The Planning Inspectorate

**Date:** 13 June 2025

**Dogger Bank South Offshore Wind Farms Project: Environment Agency response to Rule 17 letter (9 June 2025)**

Title:
Environment Agency Flood Map for Planning (Updated 2025)

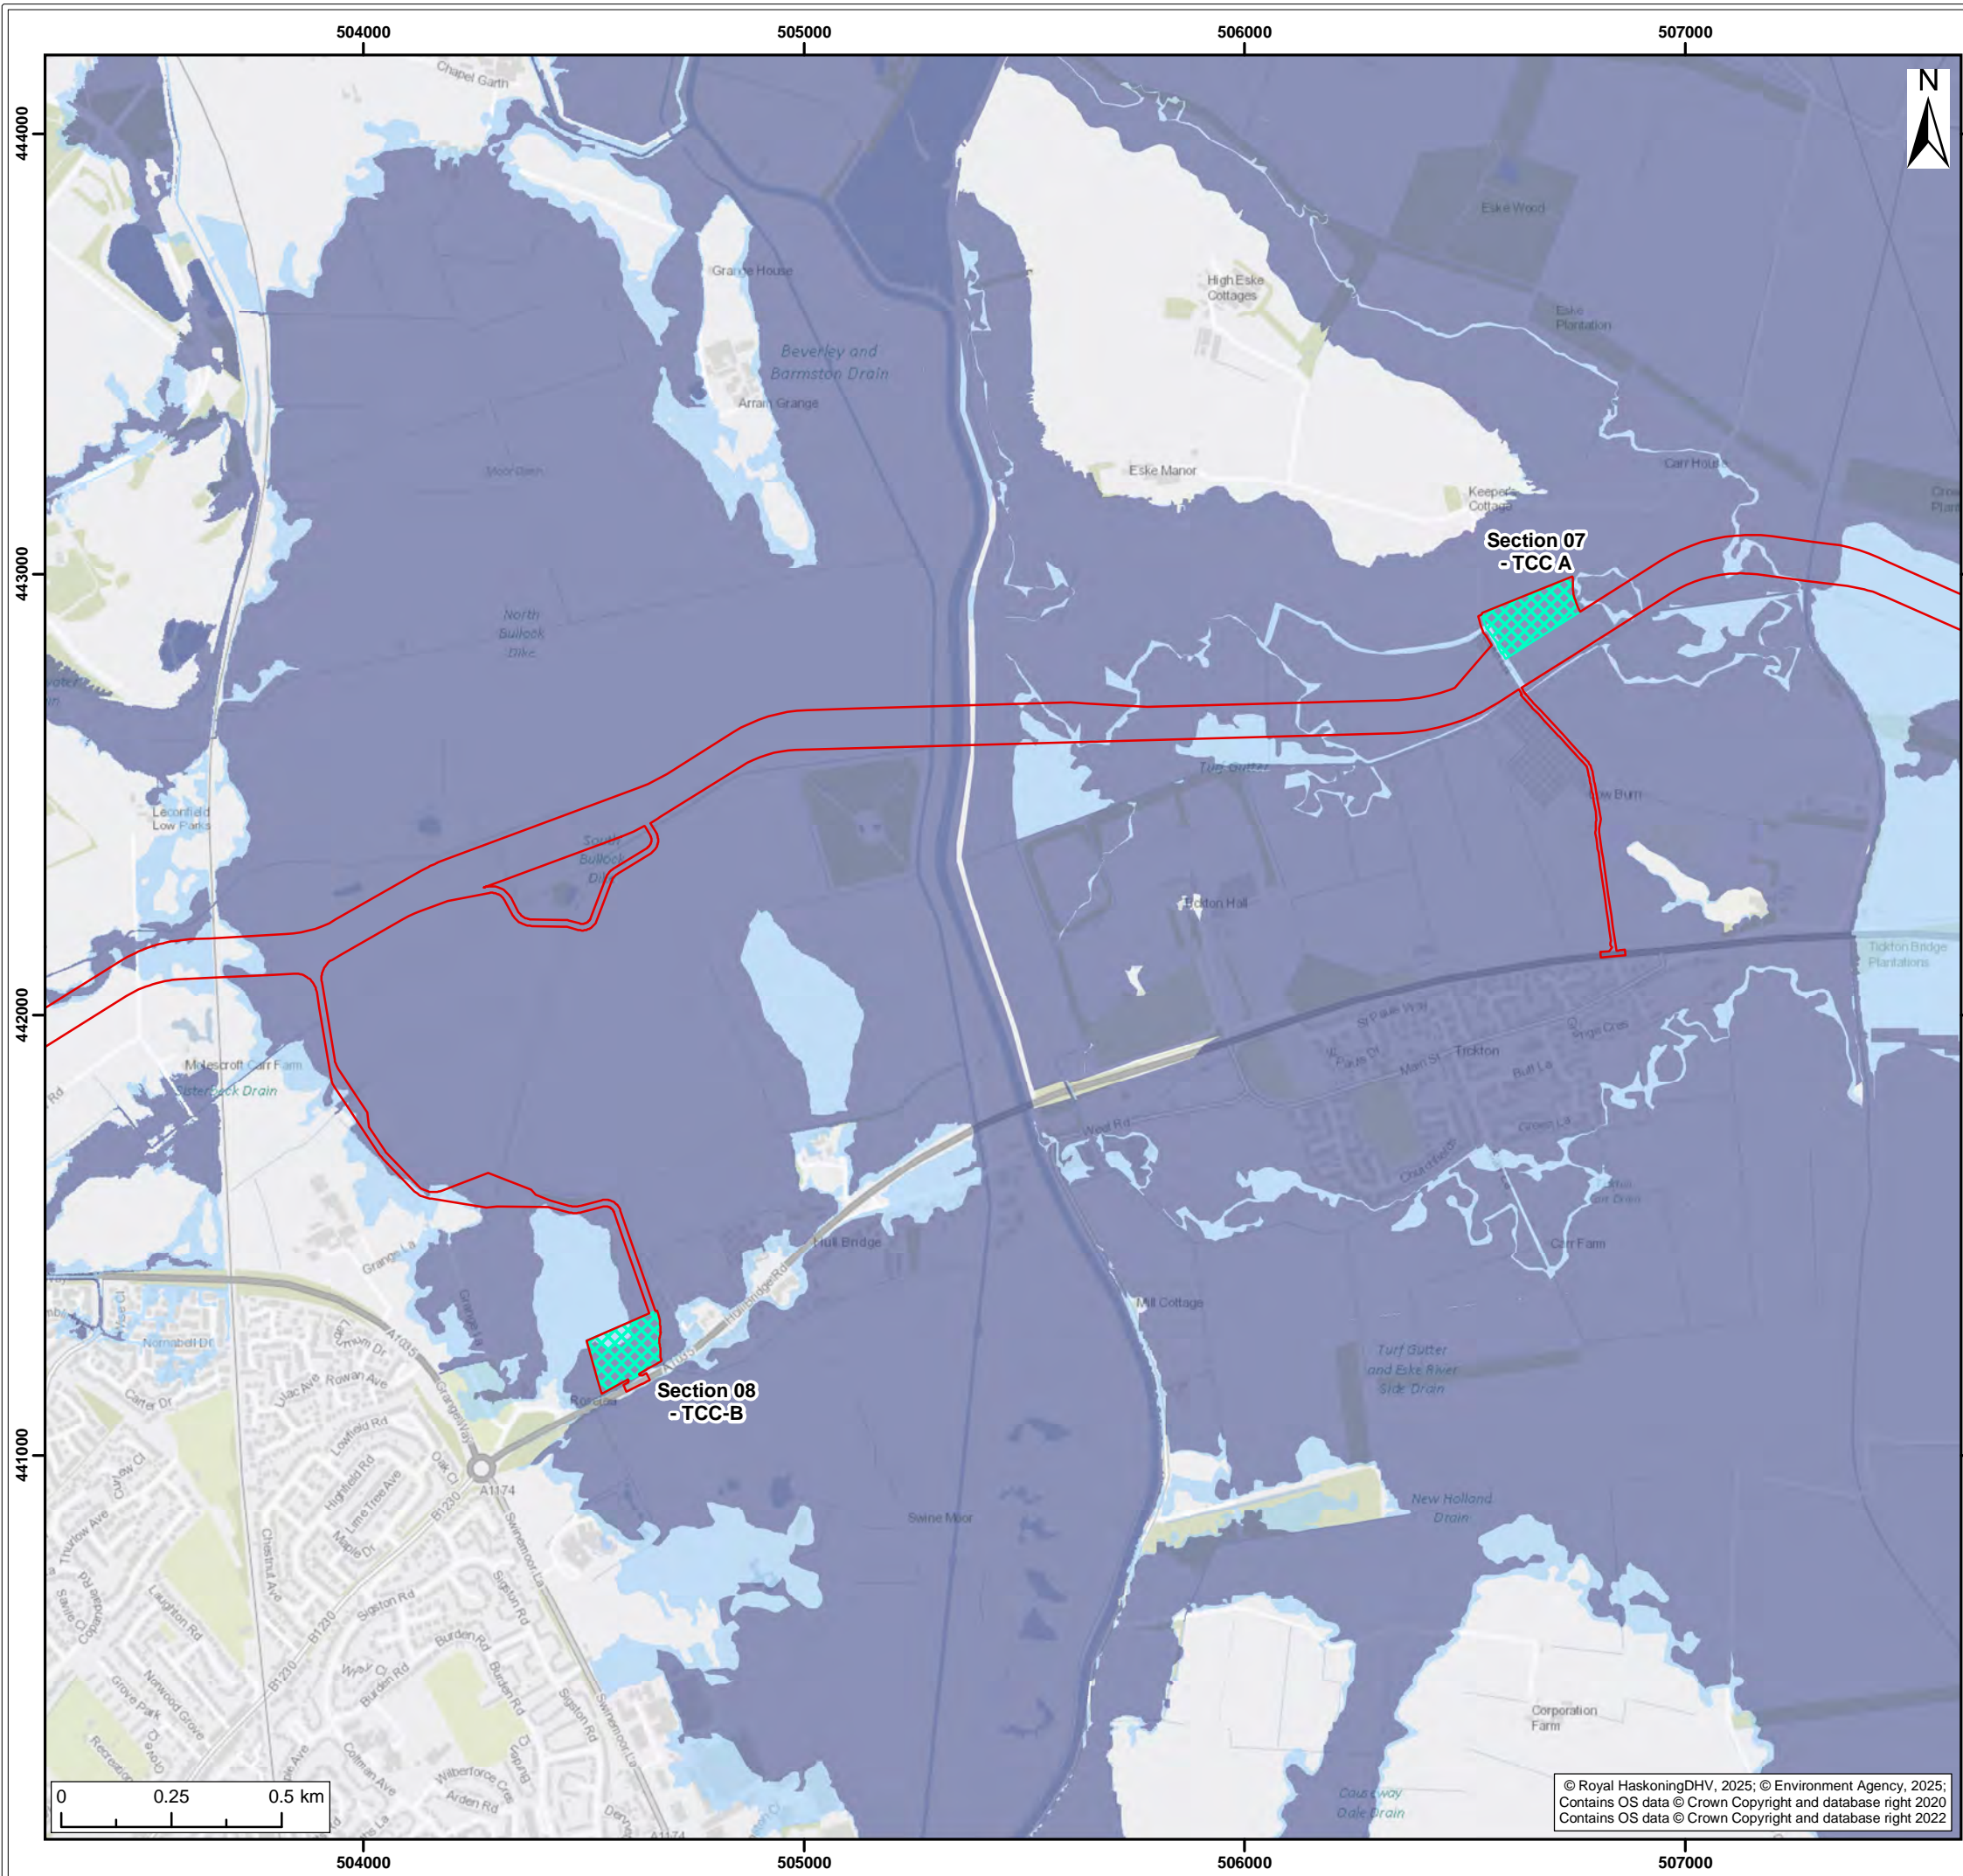
We have reviewed the *Flood Risk and Climate Change Technical Note [REP5-039]* document. Within the first section of the report, the applicant has undertaken an analysis of the full route with the updated flood risk information. We presume no further compounds were brought into a flood risk area because of the new information? Please could the applicant confirm that this is the case?

Extracts of modelled flood outlines for the 1 in 100 year event
Section 8 – TCC B

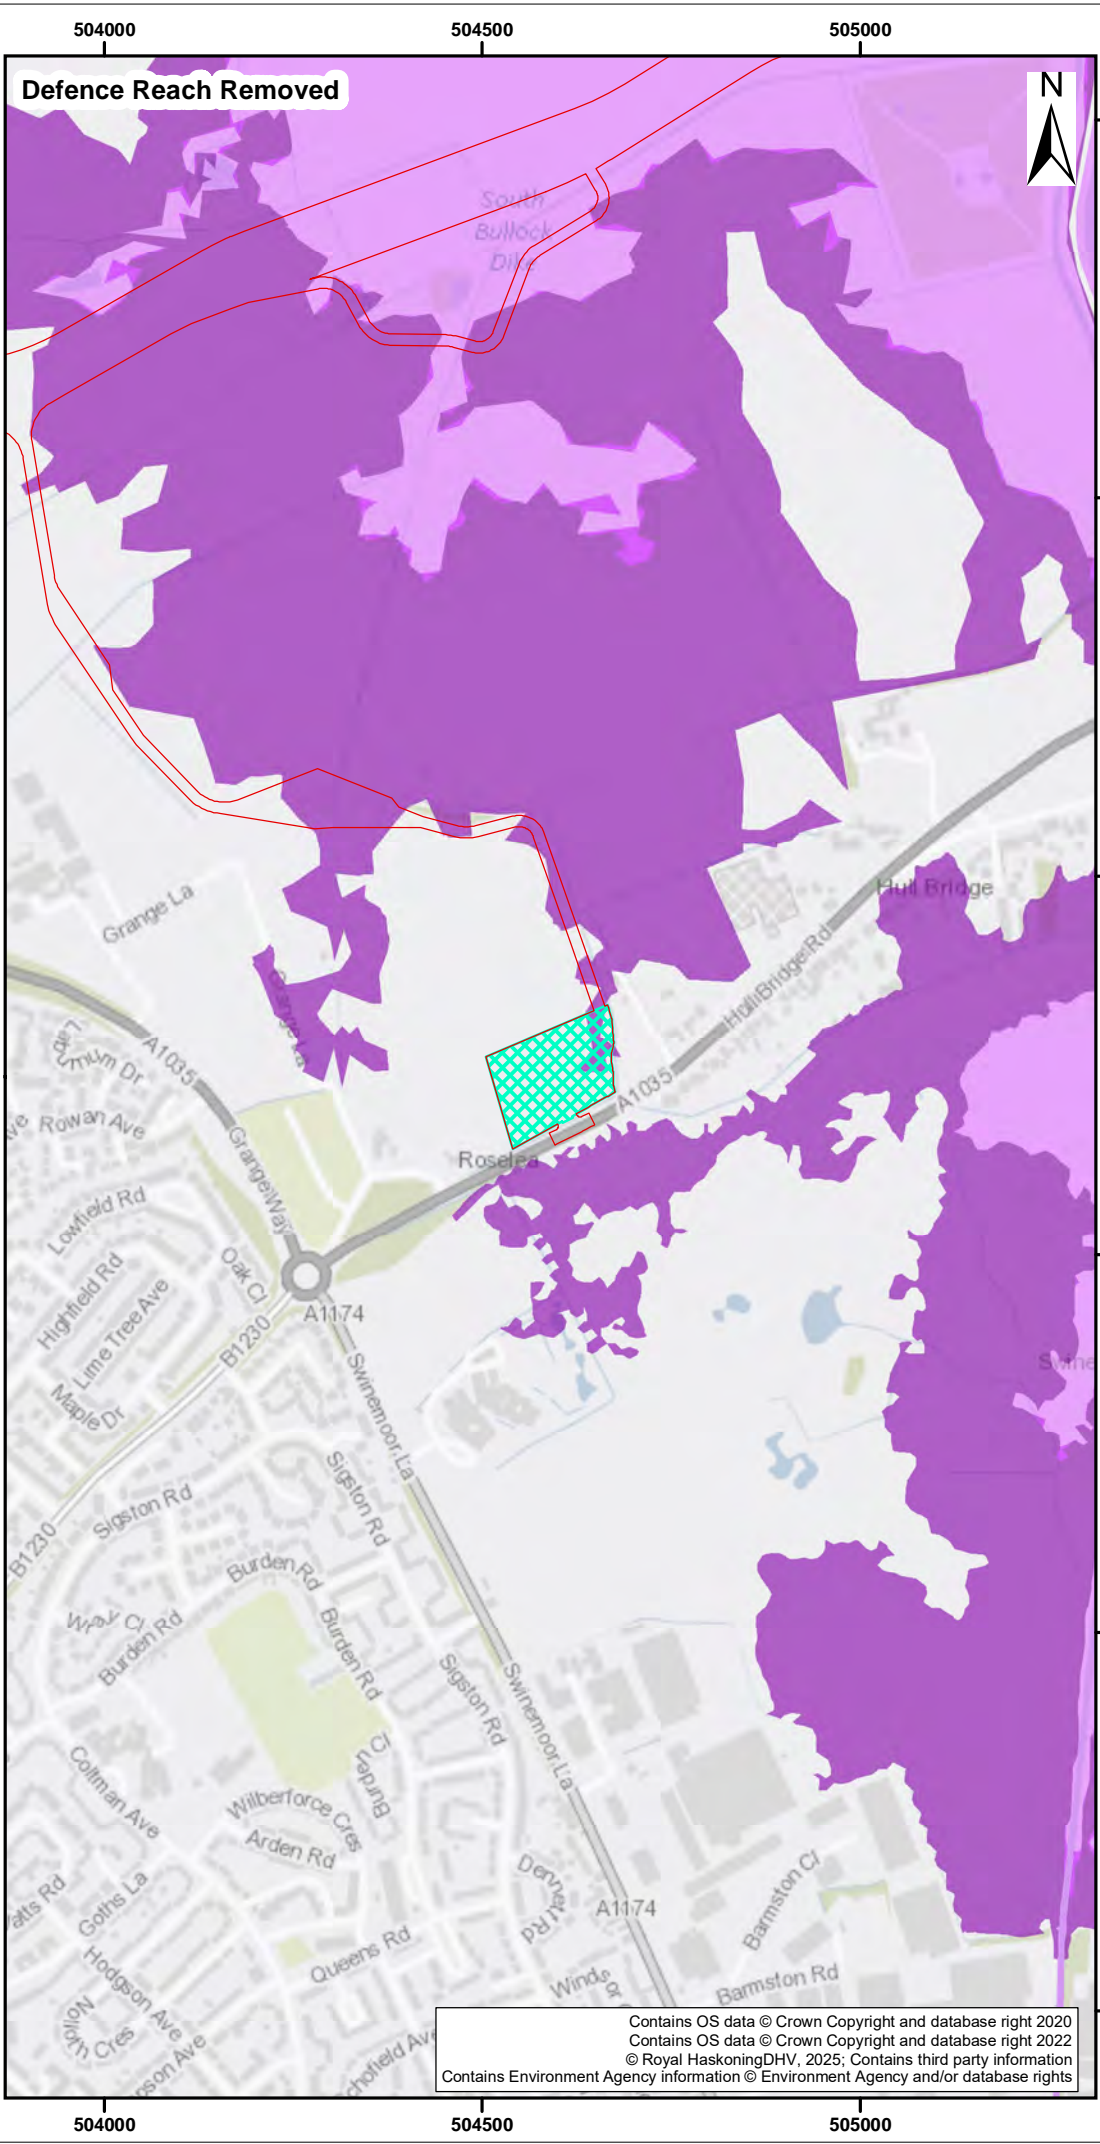
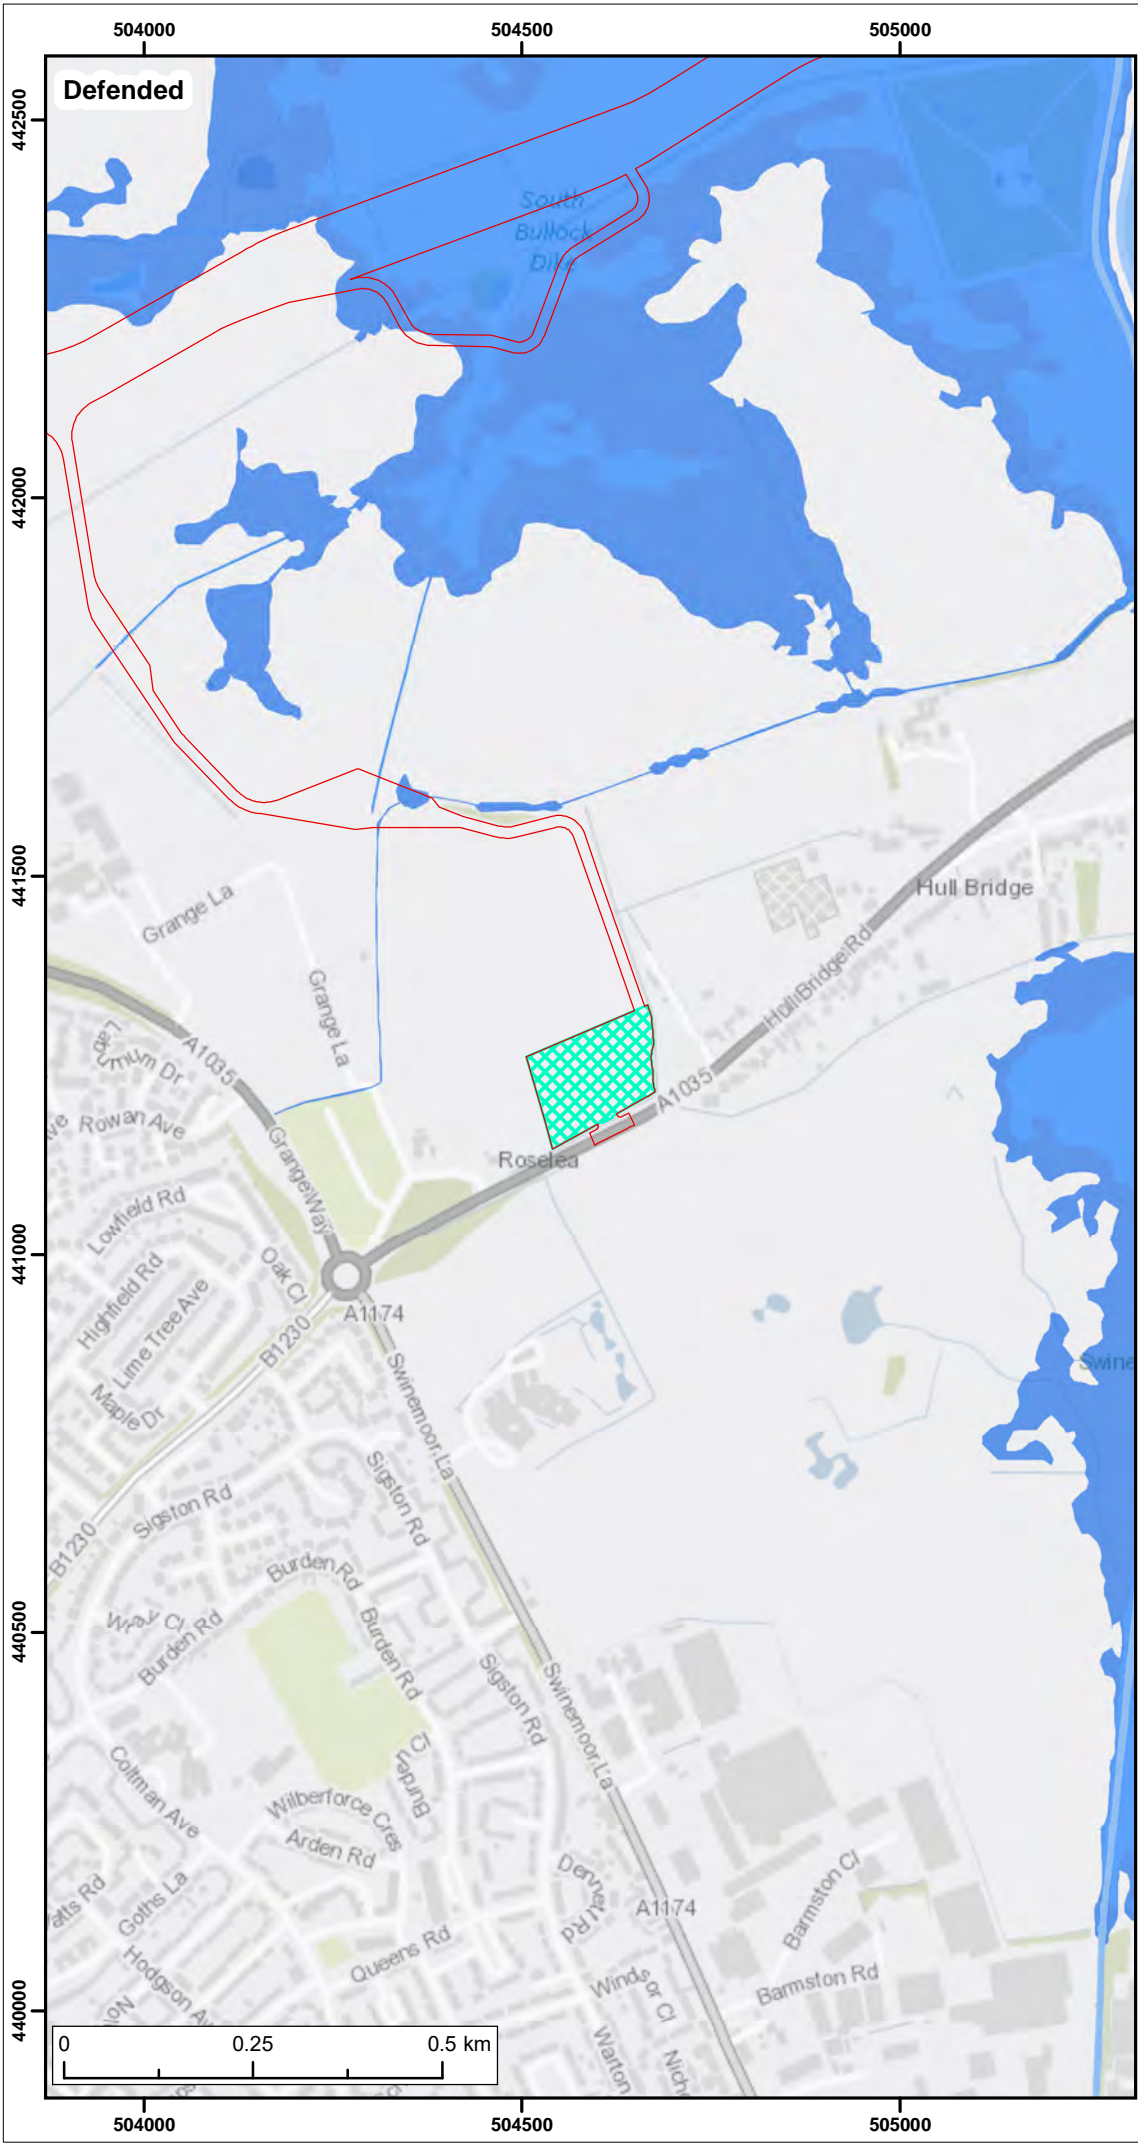
In relation to Section 8 – TTC-B we seek further clarification on one point. Within the report it states that the site is only impacted by a 'defence reach removed' scenario. However, we note that this has not been considered further as the applicant have stated that the Environment Agency are unlikely to remove a section of defence within the short term. Although the Environment Agency do not intend to remove any sections of defences within the locality, there is always a residual risk of flooding, and if a bank were to fail it could have a similar impact to a defence removed. Therefore, it would make sense to use the worst case scenario (i.e. one that you know could get to the site) as part of this analysis.
